# City of Portland, Maine - Building or Use Permit Application

Permit No: 04-0273  
 Issue Date: MAY 2 8 2004  
 CBL: 061 E008001

Proposed Project Description:  
Remodel - Kitchens, bathrooms, add new skylights add new 3rd fir bath to each of two units

Proposed Use:	Proposed Project Description:
Duplex: Amendment to permit #04-0273: remodel kitchens, baths, add 3rd floor bath to each unit	Amendment to permit #04-0273: remodel kitchens, baths, add 3rd floor bath to each unit

REVISED 5/25/04

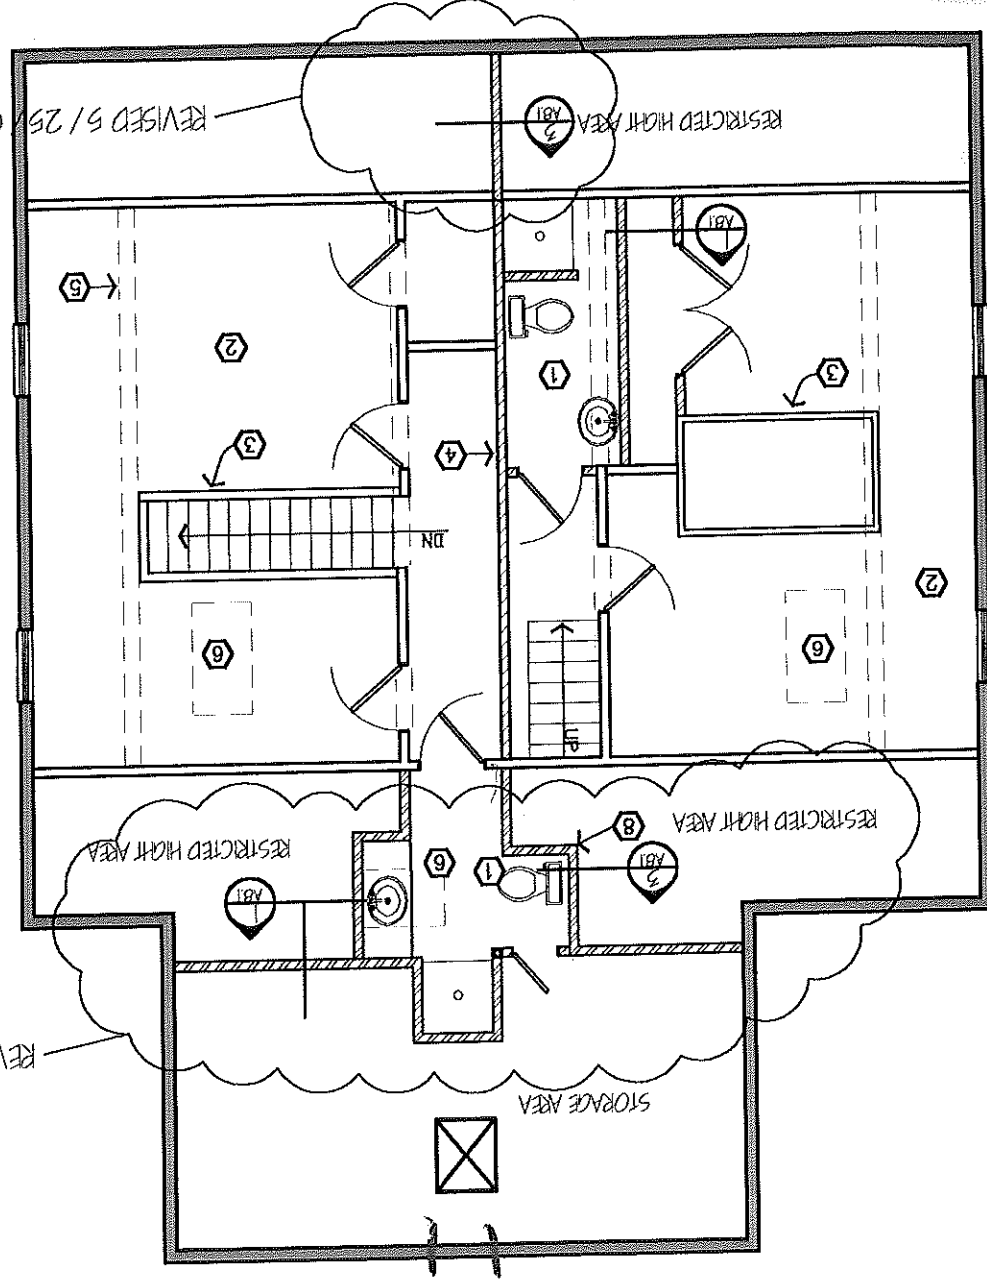
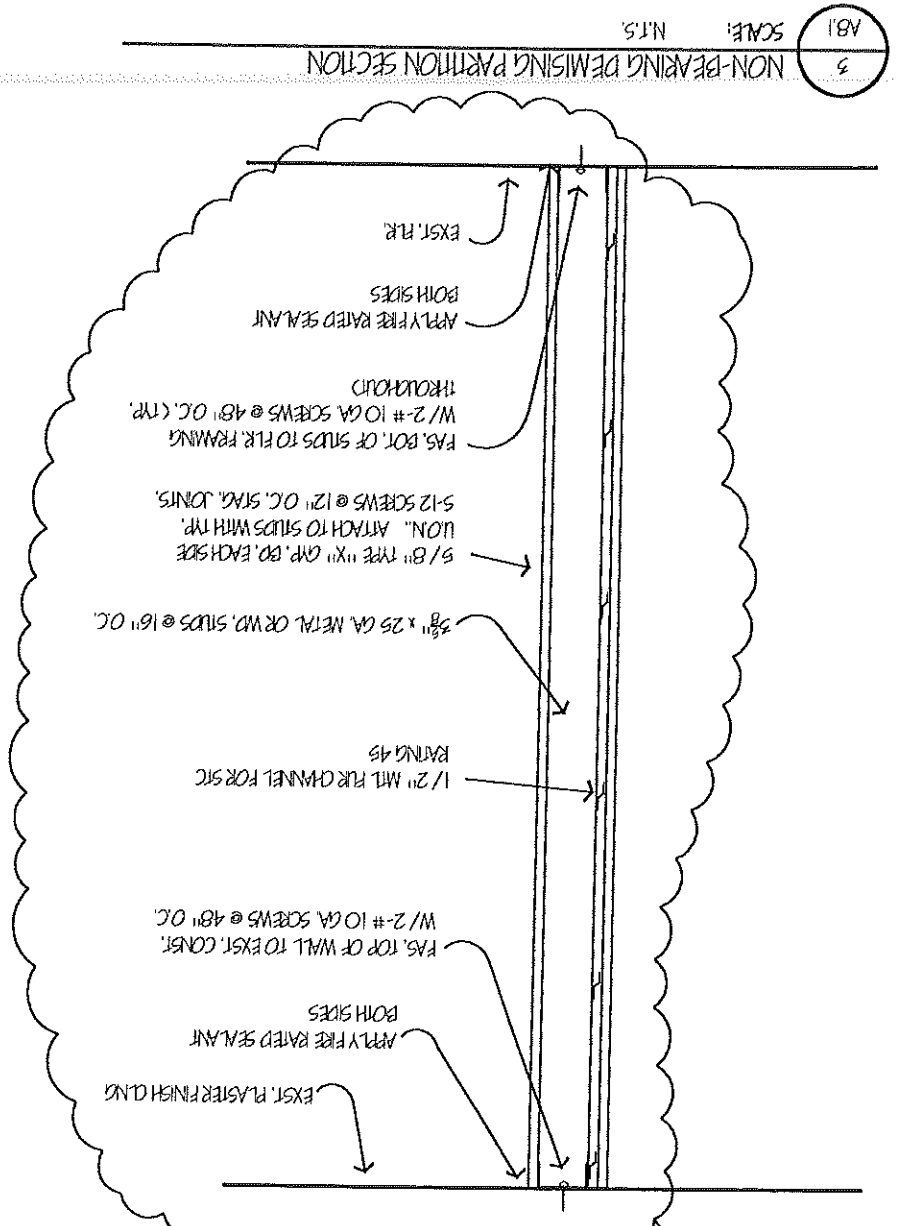
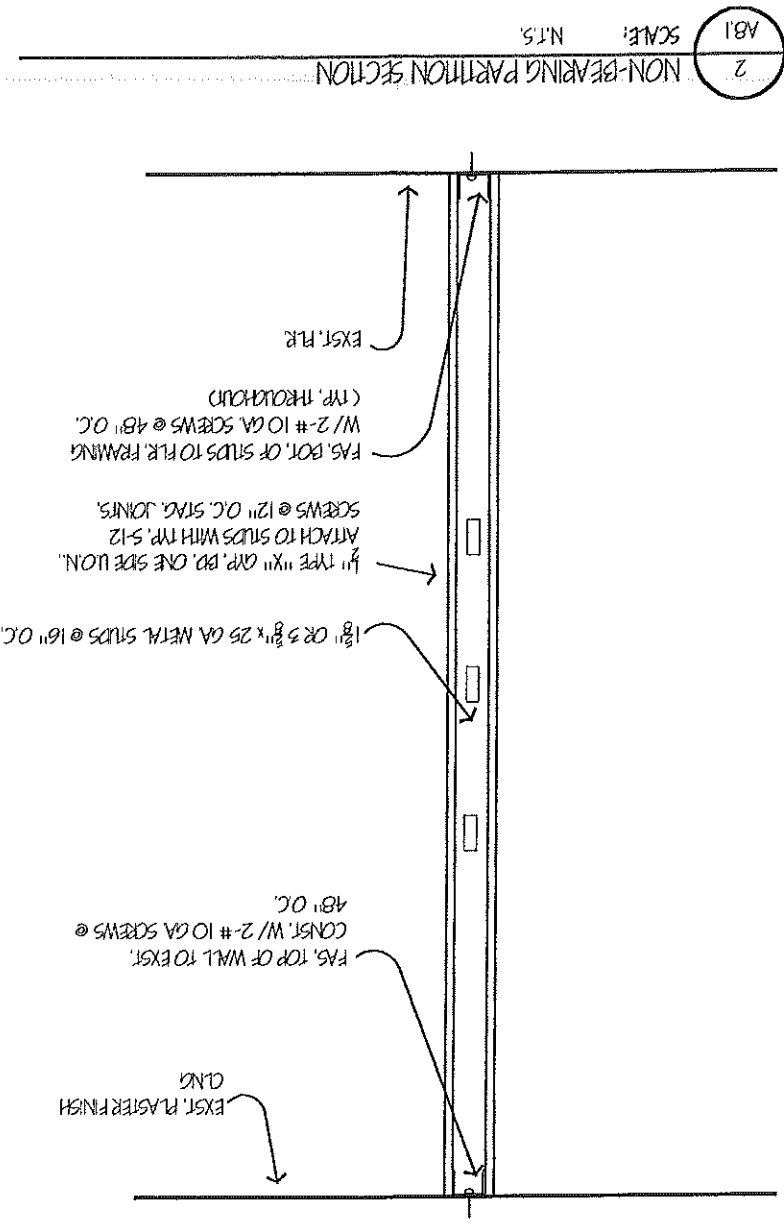
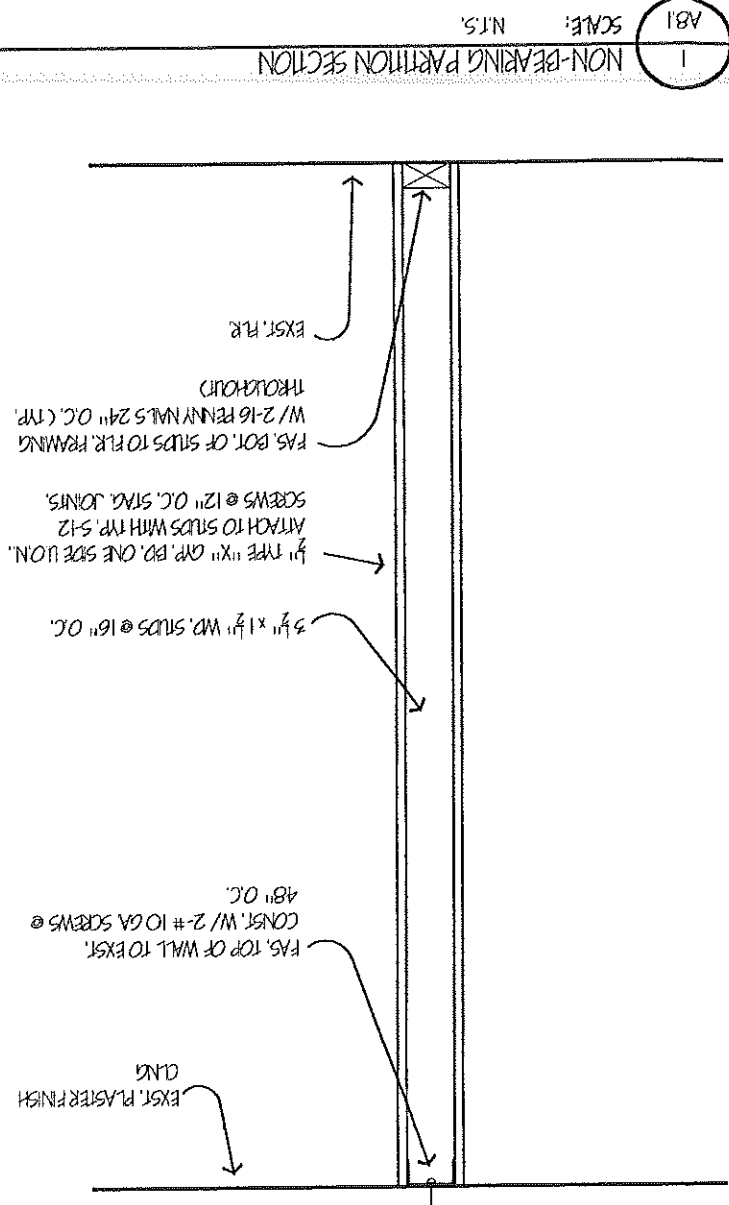
**Dept:** Building      **Status:** Approved with Conditions      **Reviewer:** Tammy Munson      **Approval Date:** 05/19/2004  
**Note:**  
 1) As discussed during the review process, the seperating wall between dwelling units must be a minimum of 45 STC and rated for hour. (please see attached copy)  
 2) As discussed during the review process, all windows located within 36" horizontally and within 60" vertically of the standing surface of any tubs/showers/whirlpools must be tempered glass.
